CITY OF ALBUQUERQUE

RE: **La Madeleines**
2110 Louisiana Blvd NE
Grading Plan and Drainage Report
Engineer's Stamp Date 12/12/2016 & 1/3/2017 (File: J19D071B)

ENGINEER'S SEAL  DAVID SOULE P.E. #14522	LA MADELEINE		DRAWN BY WCWJ
	GRADING AND DRAINAGE PLAN  <i>Rio Grande Engineering</i> 1606 CENTRAL AVENUE SE SUITE 301 ALBUQUERQUE, NM 87106 (505) 872-0989		DATE 12-12-16 21634-14522-10-25-16
			SHEET # C001
			JOB # 21634

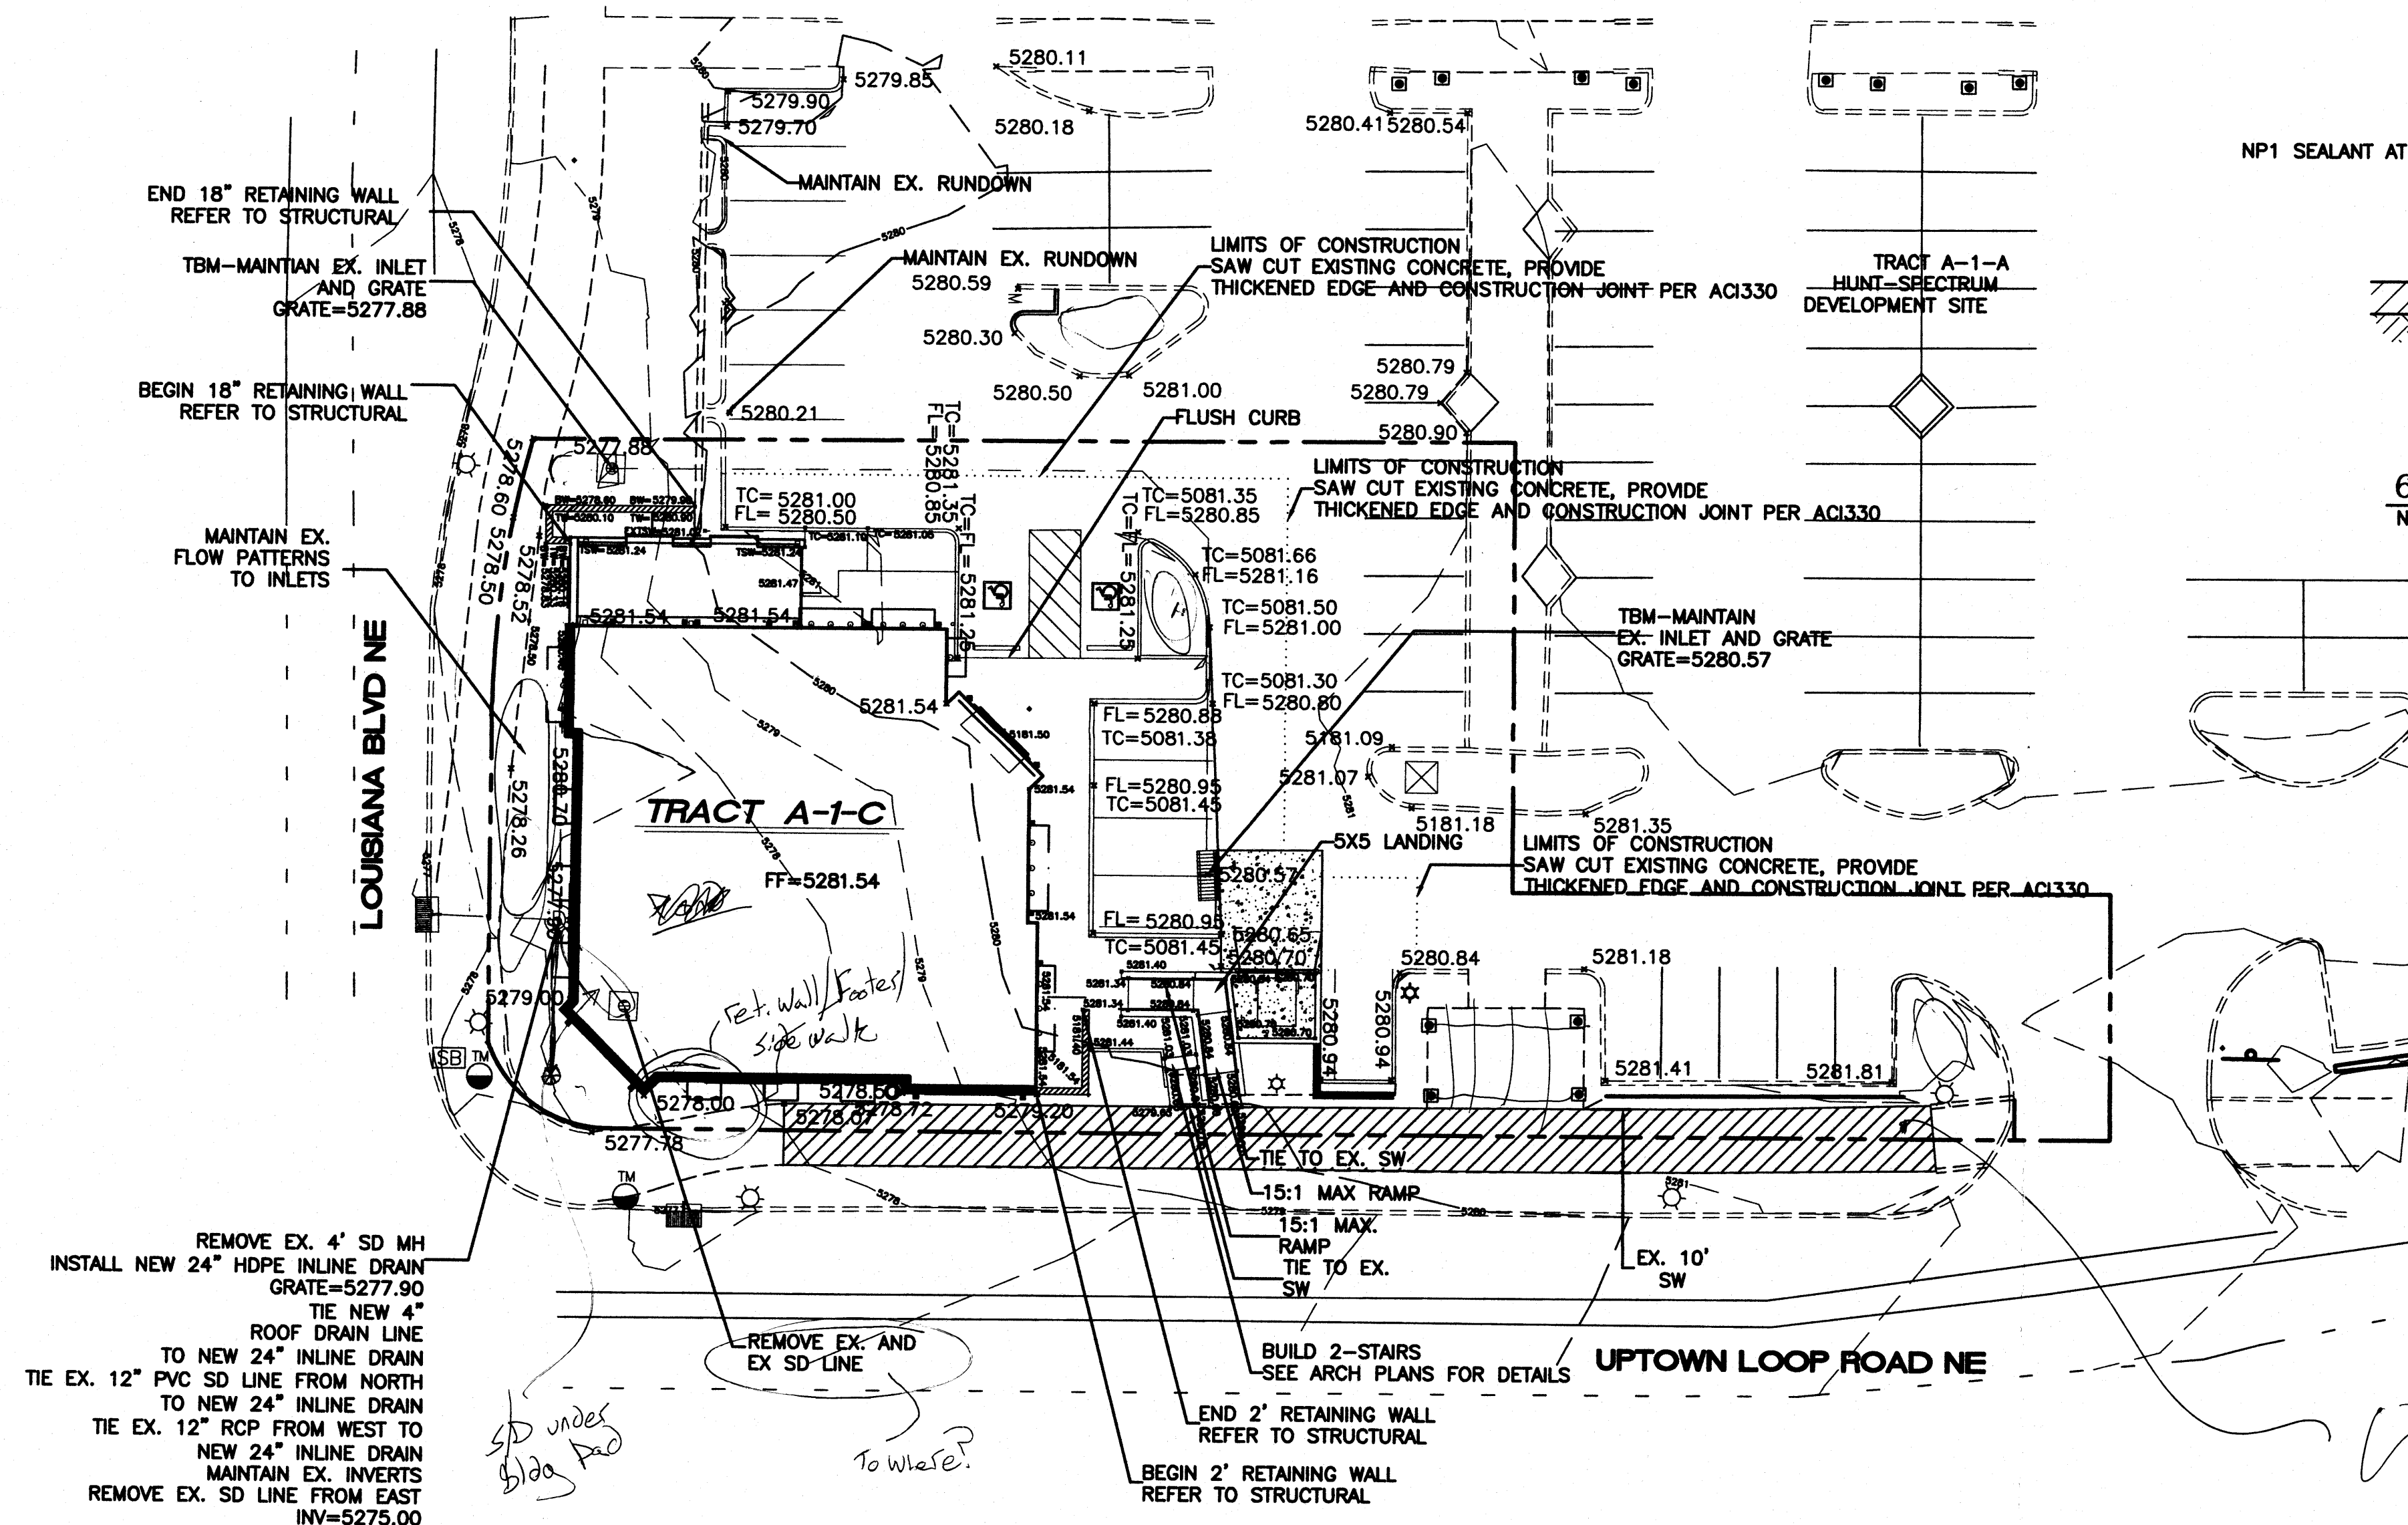
1. First Flush Storm water quality standards do apply. Detention of the first flush volume, indicated as 133 cf, is required.
2. The inlet at the southwest corner is proposed to be removed and extended, but it's not defined where the new one will be placed. Extending the line towards Uptown Loop appears to put it in conflict with the existing sidewalk, the retaining wall and its footer, and any utilities that may be there. Another option may be to remove the inlet and storm drain back to the manhole, and replace with a new inlet and storm drain running south towards the intersection. This would avoid the retaining wall and slab all together.

3. Analysis of the private storm drain system showing capacity of the system due to changes in flow paths is required. Additionally, show flow directions from the roof and for the regraded site.

4. The drainage area for the dumpster will need to include a grease trap and be routed into the sanitary sewer system.
5. Are there any existing sidewalk or utility easements for this site?
